Office of
Environment
& Heritage

DOC18/908962
SSD 8865

Notice of Exhibition – Concept Proposal for Redevelopment of St Anthony of Padua Catholic School (SSD 8865)

Attachment 1 – OEH comments on Concept Proposal for Redevelopment of St Anthony of Padua Catholic School (SSD 8865)

FIGURE 3
CATHOLIC SCHOOL DEVELOPMENT
EXISTING CASE
1% AEP PEAK FLOOD LEVELS & DEPTHS

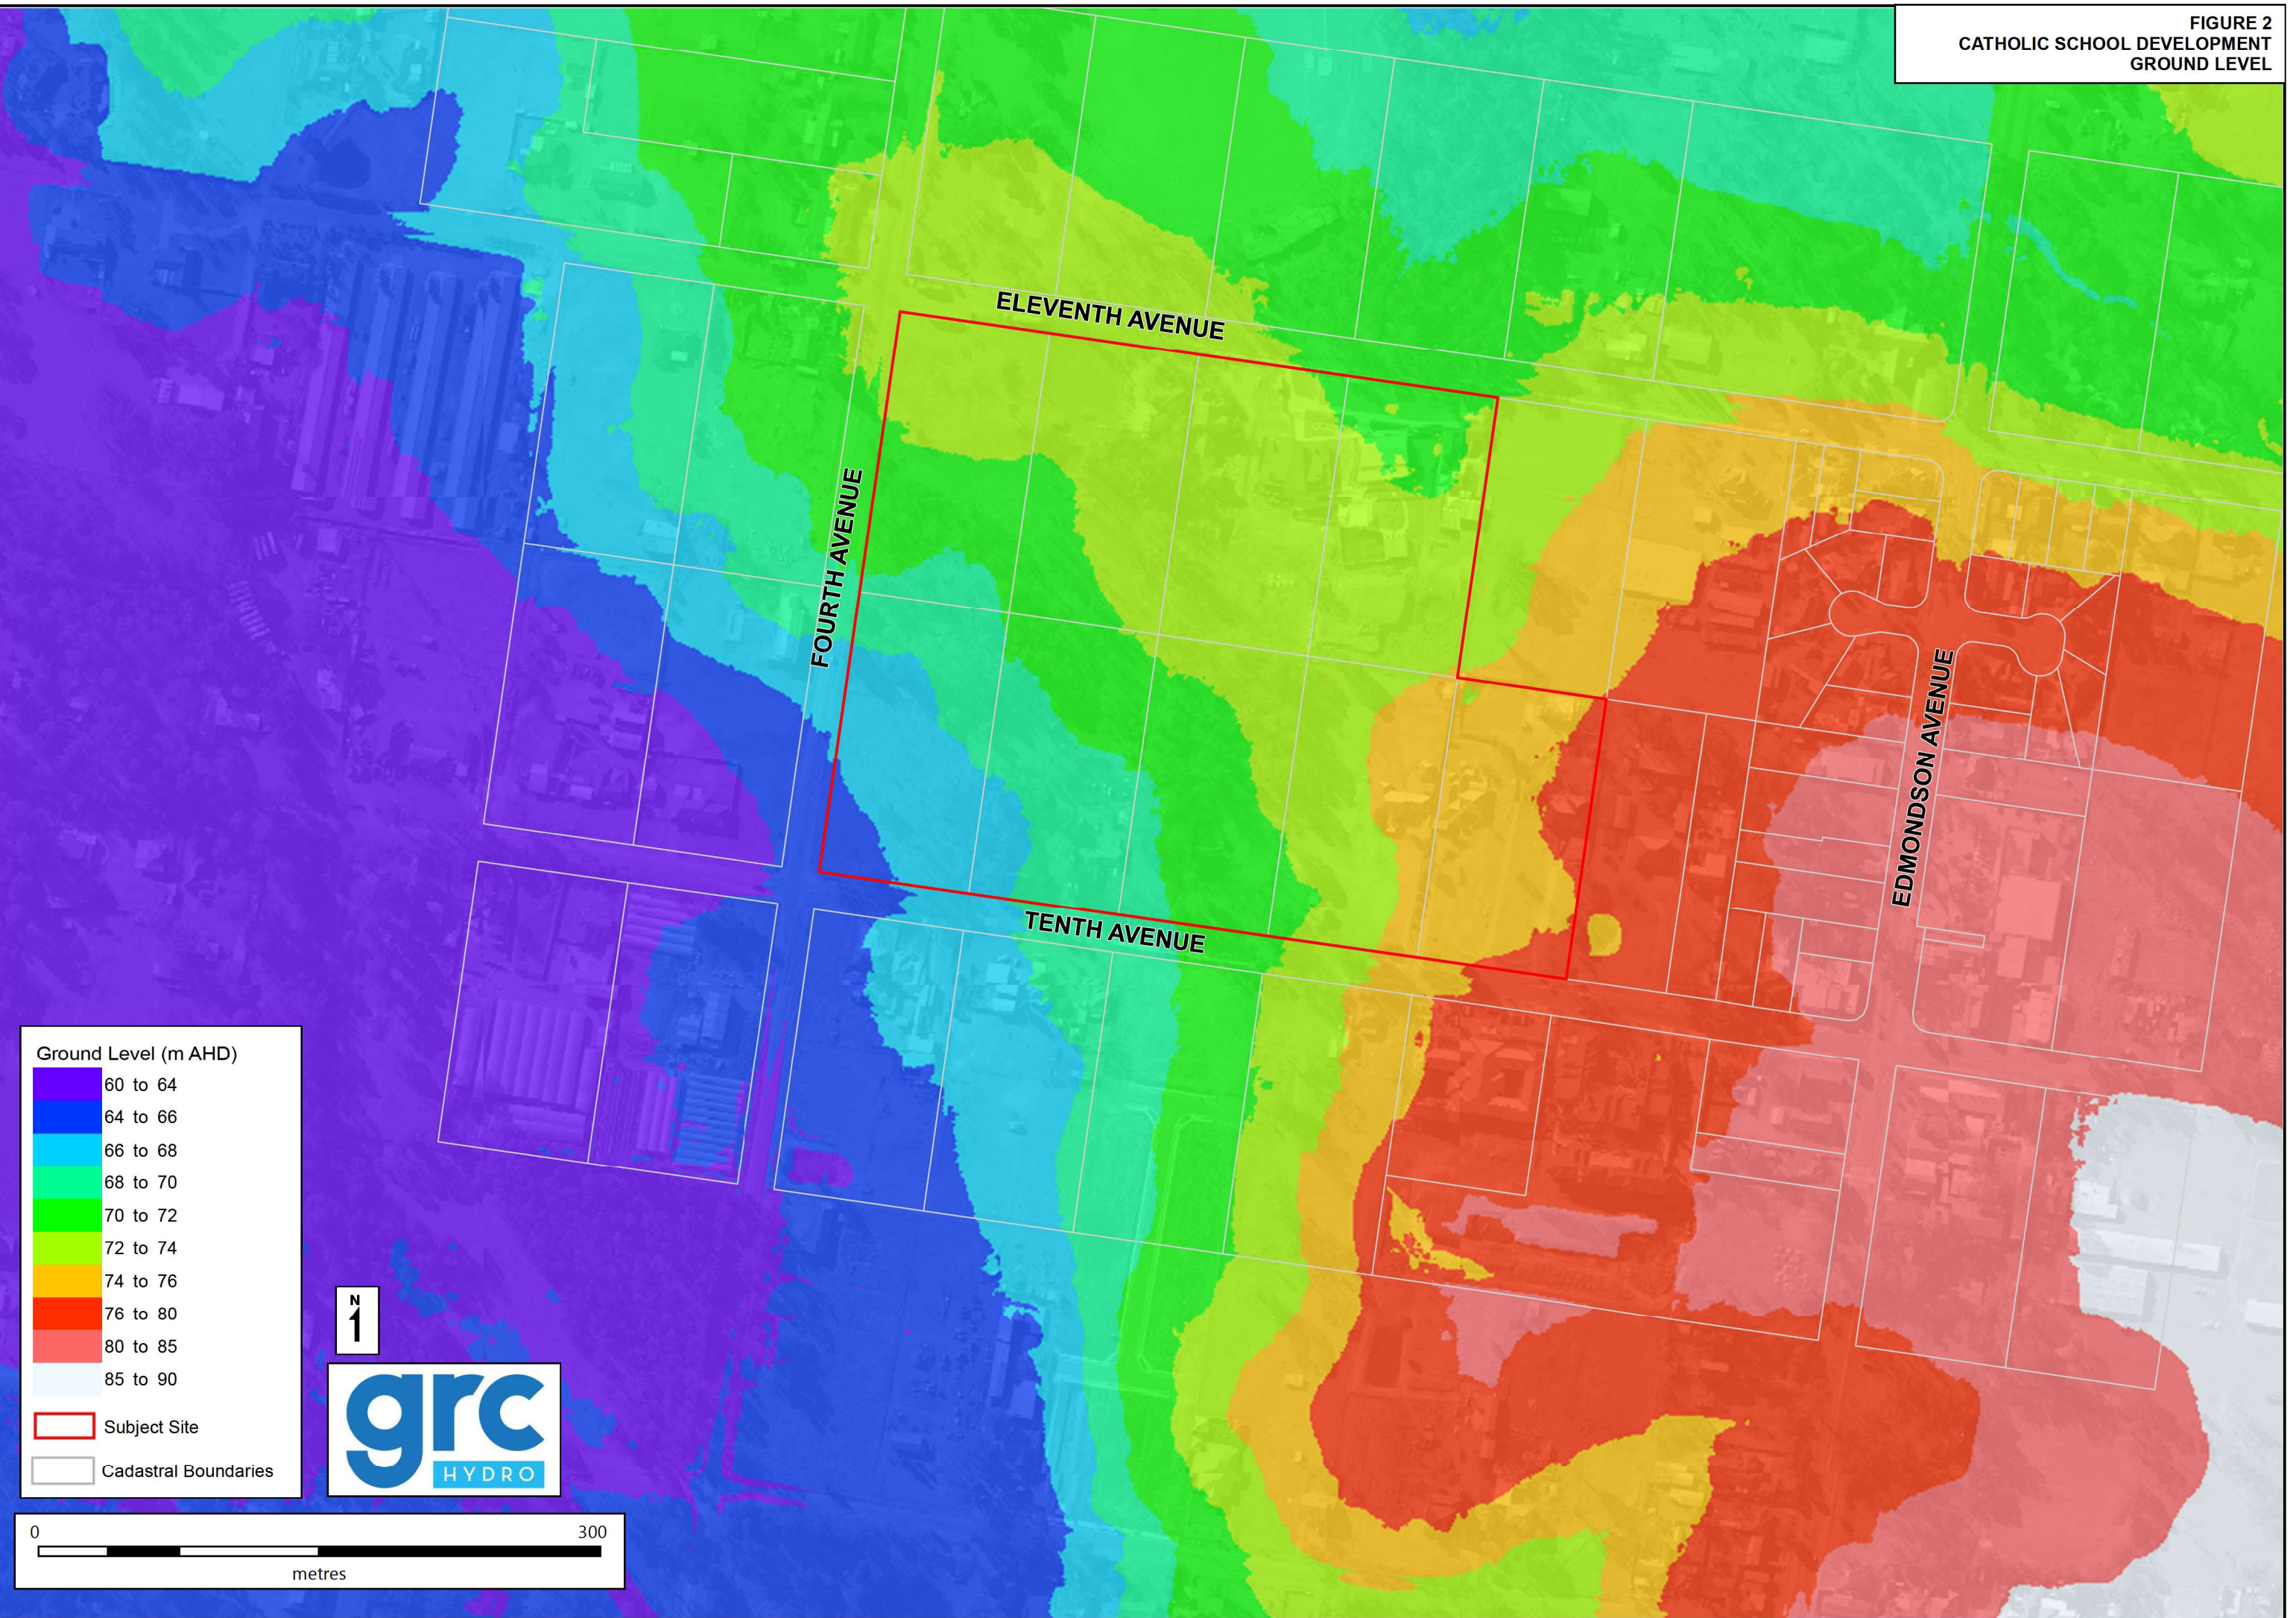
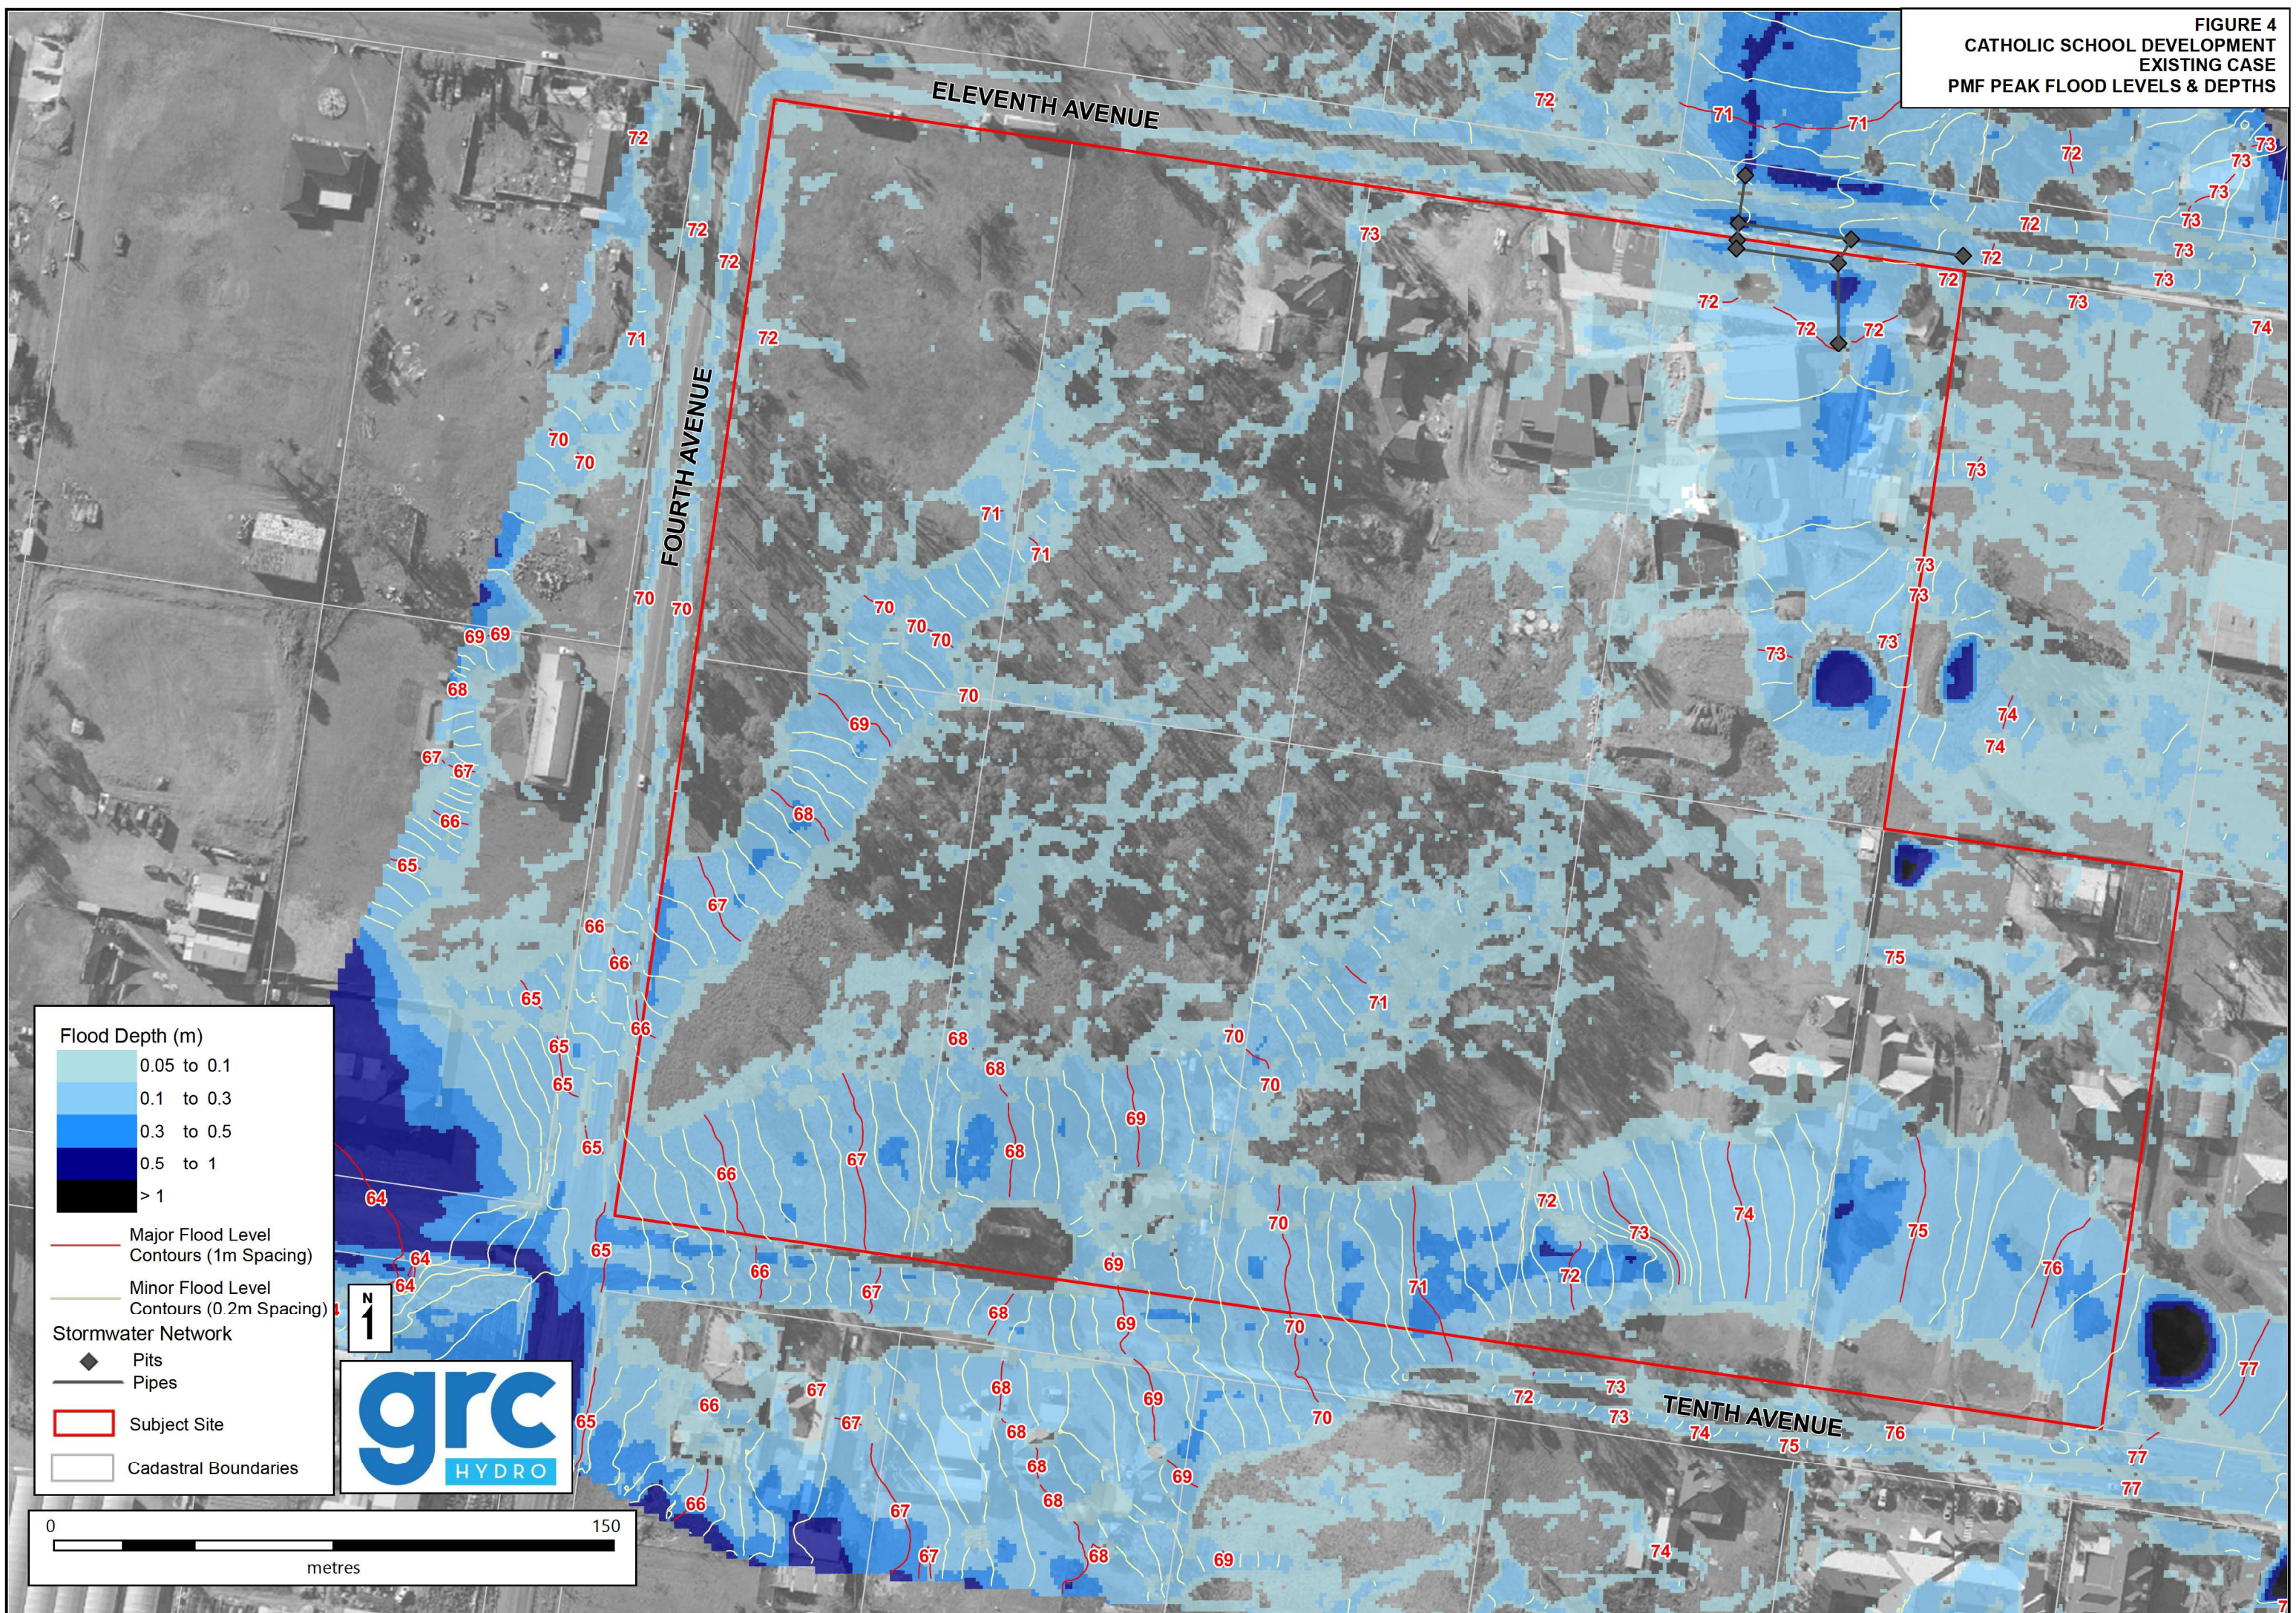
- The flood maps (grc Hydro, July 2018) included in Appendix R (Part 2) appear to have inconsistencies between the existing conditions and the proposed development conditions. Figure 4 for the existing conditions shows minor flood affectation in the 1% AEP at the southern end of the development site (i.e. Tenth Avenue), while Figure 5 shows widespread flooding across the site particularly across the south west and southern areas. Also, the flood maps under developed scenarios do not show any flood affectation at these locations. These inconsistencies need to be checked, corrected and updated in the report in order to have sound understanding of flood behaviour within the site for the proposed development.
